OXFORDSHIRE COUNTY COUNCIL'S RESPONSE TO CONSULTATION ON THE FOLLOWING DEVELOPMENT PROPOSAL

Application no: 16/00219/REM

Proposal: Reserved matters to 14/01737/OUT - Appearance, landscaping, layout and scale of 45 no. dwellings

Location: The Paddocks The Hale Chesterton OX26 1TN

Title Hard Landscape Proposals  
Sheet 2 of 2

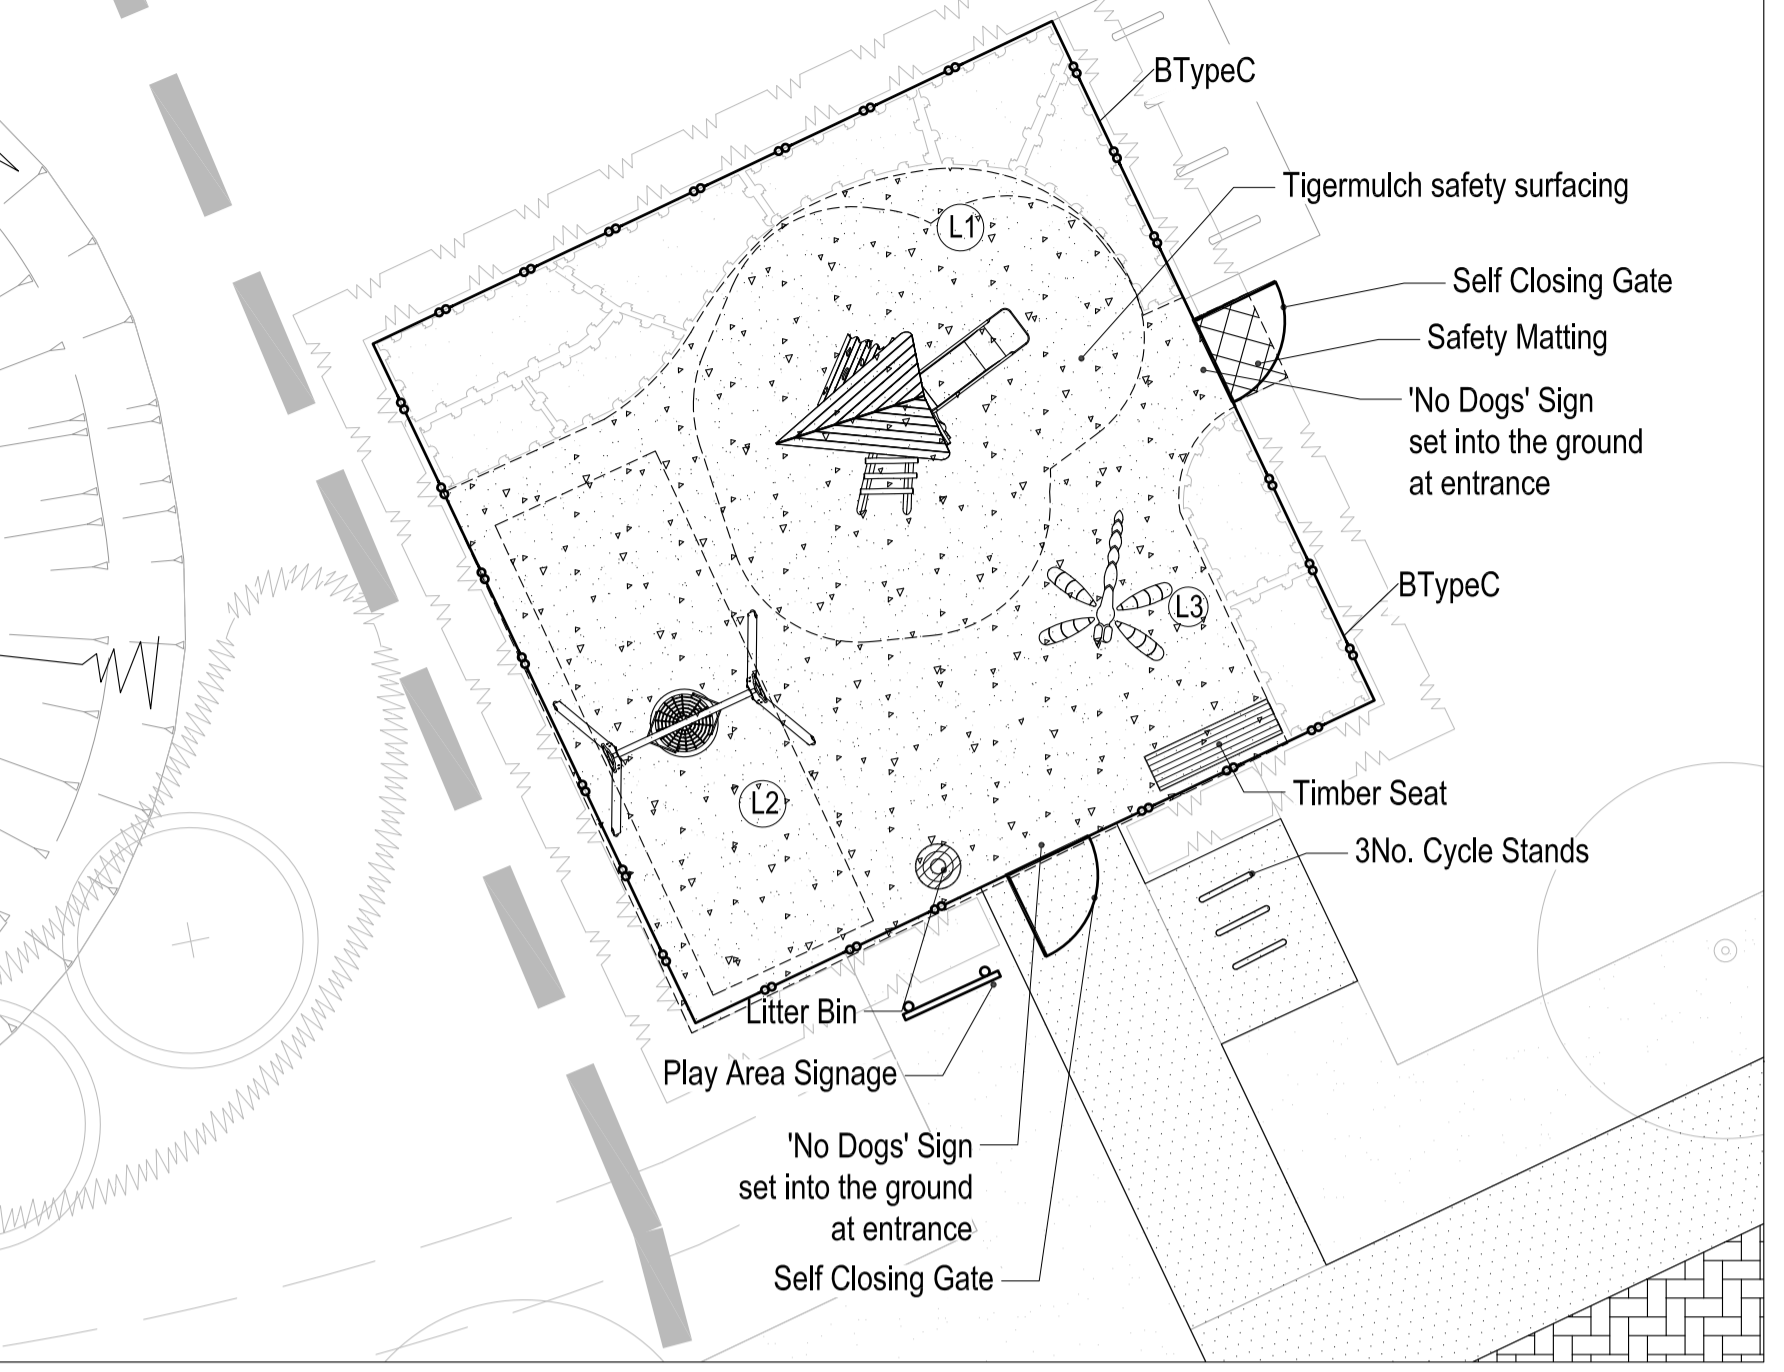
All visitor parking spaces in lay-bys must have a minimum hard standing of 0.8m wide to allow occupants to step out and around of parked vehicles. The visitor lay-bys provided along the spine road show a service strip besides the bays which is should be hard surfaced.

Also the two visitor lay-bys fronting plots 9-10 and 14-15 should be clearly defined for the safety of road users.

Oxfordshire County Council will require the proposed development to proactively encourage walking and cycling especially for local trips. Clarity is needed on communal cycle parking arrangements within the development especially for the affordable housing without garages for secure cycle parking sheds, and there should be some visitor/public cycle parking at the LEAP.
